Ref: DA 220-07-2002-i MOD 5
Contact: Steven Cook

12th July 2011

Re: Cargill Beef Abattoir – Additional Irrigation Area (DA 220-07-2002-i MOD 5)

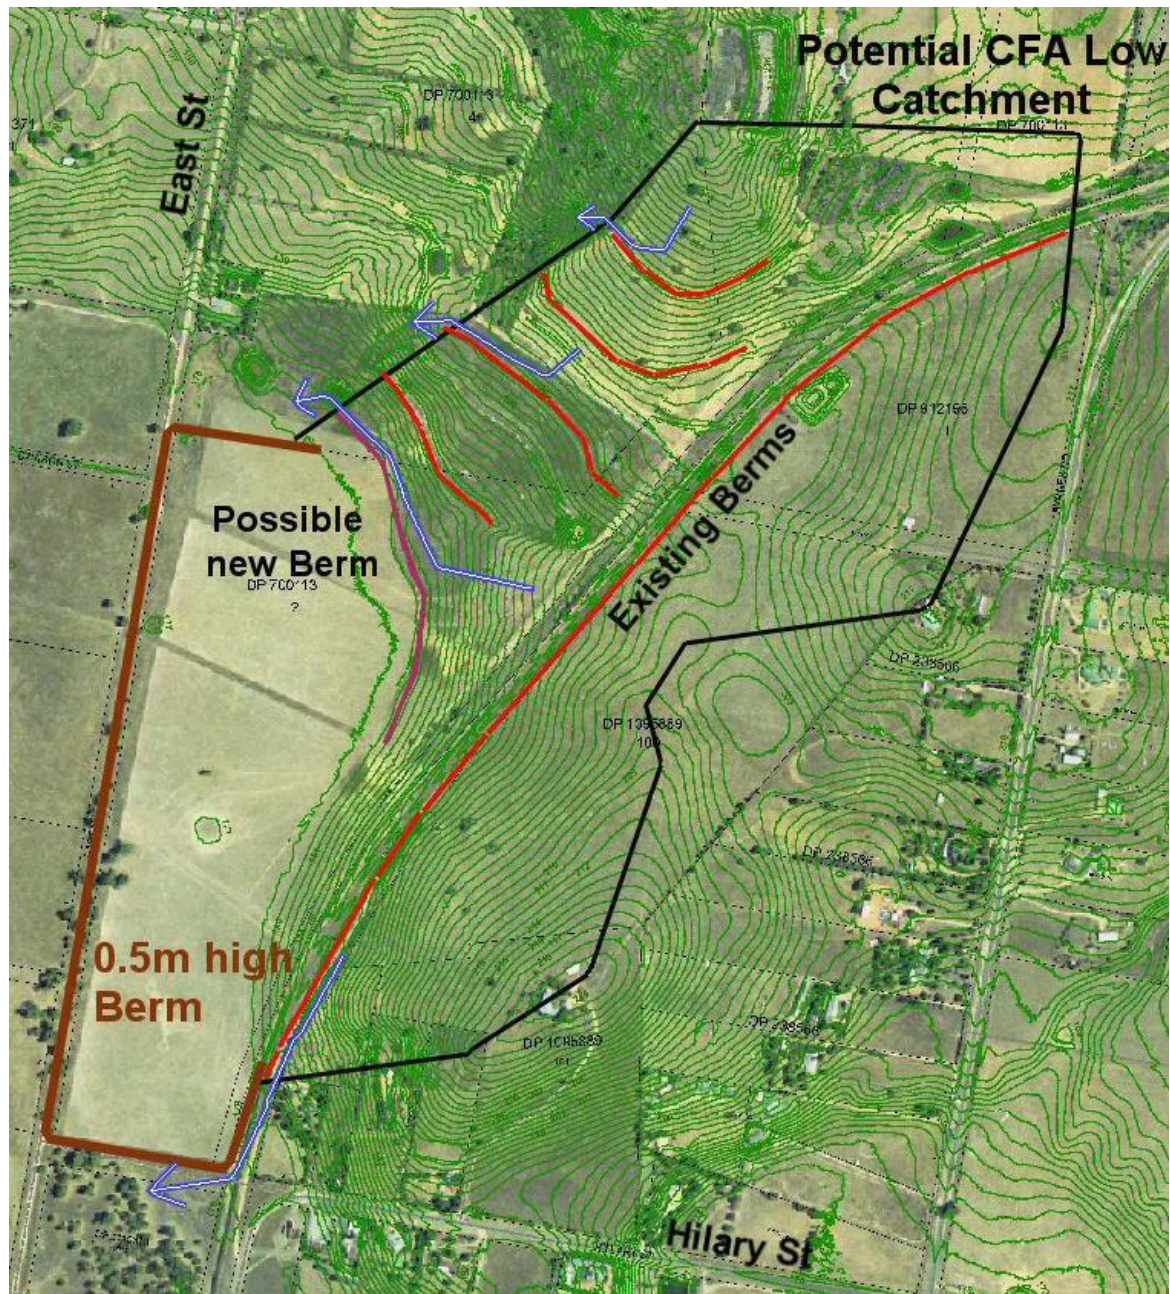
1. The proposed additional irrigation level includes land below the 1:100 Annual Recurrence Interval (ARI) Flood Event Level.
2. The additional irrigation area below the 1:100 ARI Flood Event Level is proposed to be protected by a berm with a top level of 177.8m AHD, which is 1.1m below the quoted 1:10 ARI Flood Event of 179.9m AHD. Therefore the proposed irrigated area may be regularly inundated and allow the escape of potential contaminates.

3. Council does not support the inclusion of any land below the 1:100 ARI level within the irrigation area due to the potential it creates for contaminants to enter flood waters. This would require that the irrigation area be restricted to above 181.9m AHD.

4. Council would not support an increase in the height of the berm to protect against more flood events due to the impacts this would have on the flow of flood waters and the potential this creates for increased flooding impacts on adjoining properties.
